APPROVAL RECOMMENDED: GENERAL

Item No.	Report of the Head of Development Management and Building Control	
Address:	31 MANOR ROAD HAYES	
Development:	Erection of 1no. new dwelling comprising of 2 bedrooms with associated parking, amenity space and new vehicular access on land adjacent to the existing dwelling and the erection of a part single storey, part double storey rear extension, followed by the demolition of existing conservatory, to existing property at 31 Manor Road.	
LBH Ref Nos:	954/APP/2024/97	
Drawing Nos:	Location Plan 101 102 103 104 Planning, Design and Access Statement, January 2024	
Date Plans received:	15-01-24	Date(s) of Amendments(s):
Date Application valid	15-01-24

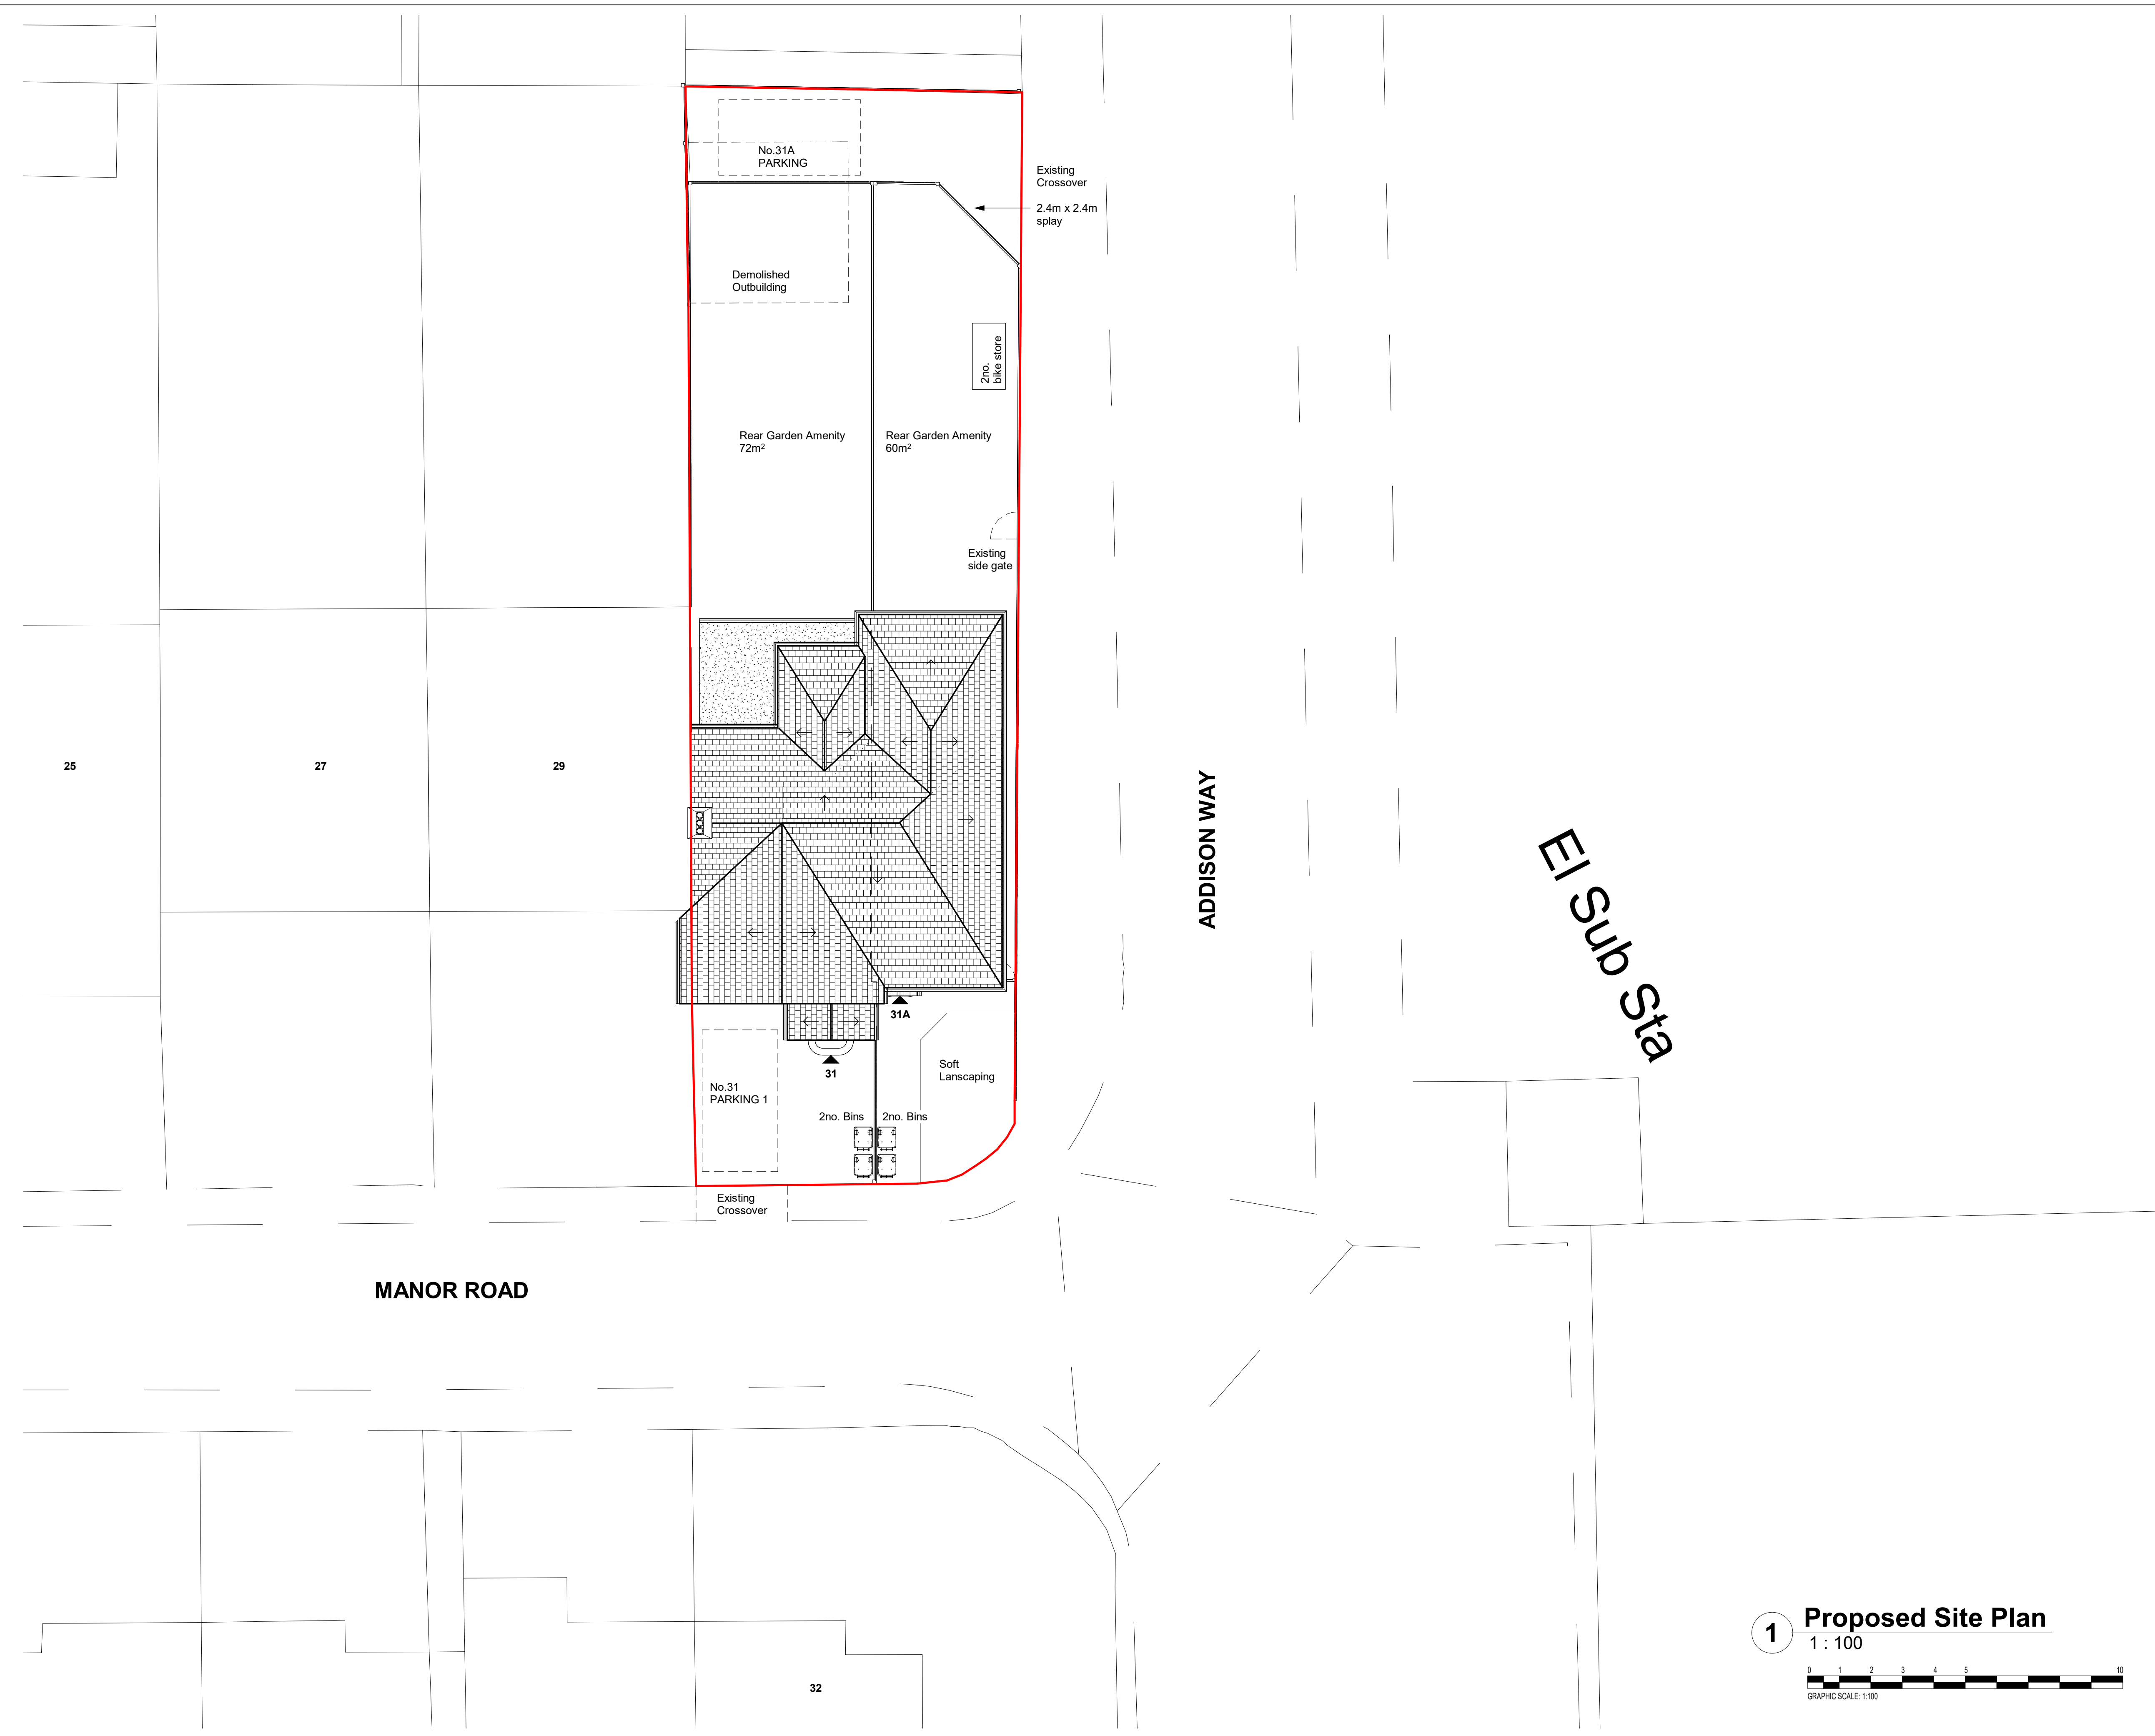
Drawing 104 titled Proposed Site Plan shows that the existing dwelling at 31 Manor Road would have 2no. parking spaces which exceeds the maximum standard and that the proposed two-bedroom dwelling would have 1no. space which would be accessed from the radius bellmouth of the junction of Manor Road with Addison Road requiring vehicles to reverse out into the junction

Drawing 104 titled Proposed Site Plan shows 2no. cycle parking spaces which is an acceptable level of cycle parking, however, the location of the cycle store is not acceptable. The London Cycling Design Standards (LCDS) 8.5.3 Residential Cycle Parking which requires cycle parking to be well located, close to the entrance of the property and avoiding obstacles such as narrow doorways (less than 1.2 metres wide) and tight corners.

However the amount of private amenity space provided for the new dwelling would not be policy compliant. Whilst the annotation on the proposed site plan (drg. no. 104) suggests a 60sq.metre private amenity space for the new dwelling, it actually measures 50sq.metres. This represents a significant shortfall and would be detrimental to the living conditions of future occupiers.
